Application by Lime Down Solar Park Limited for an Order granting Development Consent for a solar park

Network Rail Written Representations

Project Reference: EN010168

Title:
Figure 11.5 Rev 4: Lime Down D (BESS)
Fluvial and Surface Water Flood Risk Map

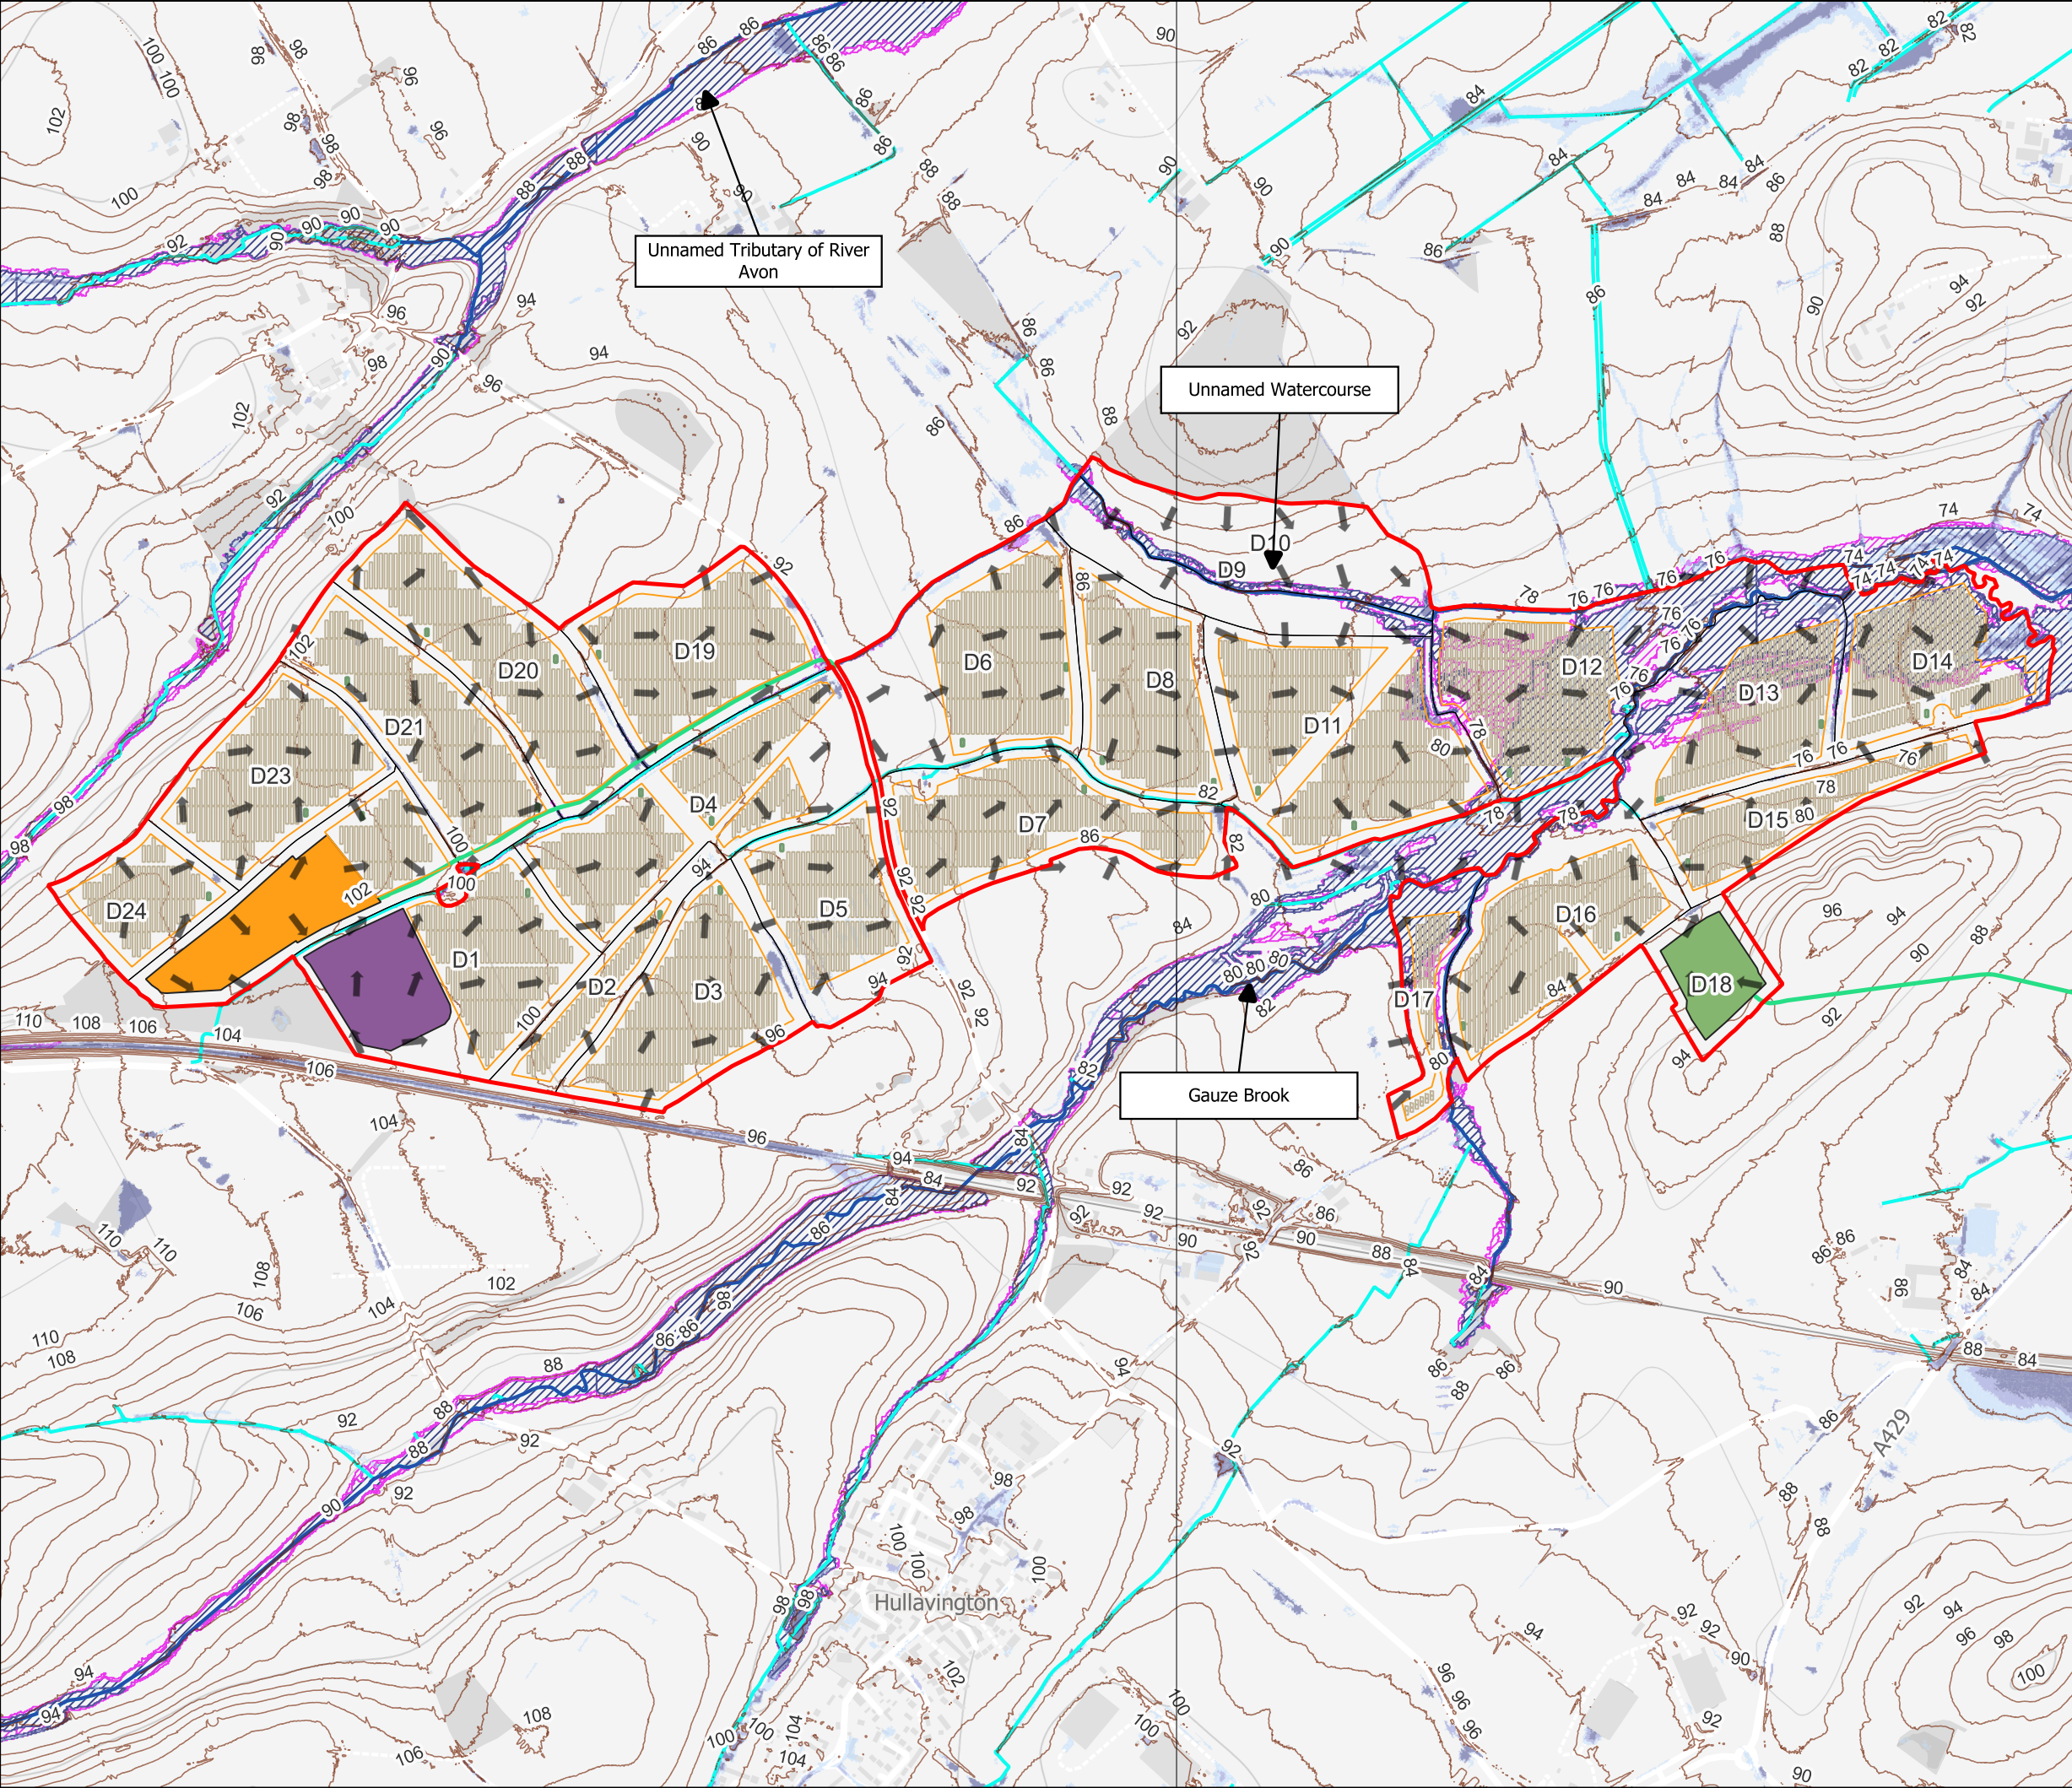
1.7.5.1 Network Rail has concerns in respect of the drainage infrastructure for the 132KV substation adjacent to the railway. Network Rail will need further details to assess the impact of any surface water run off onto the railway.
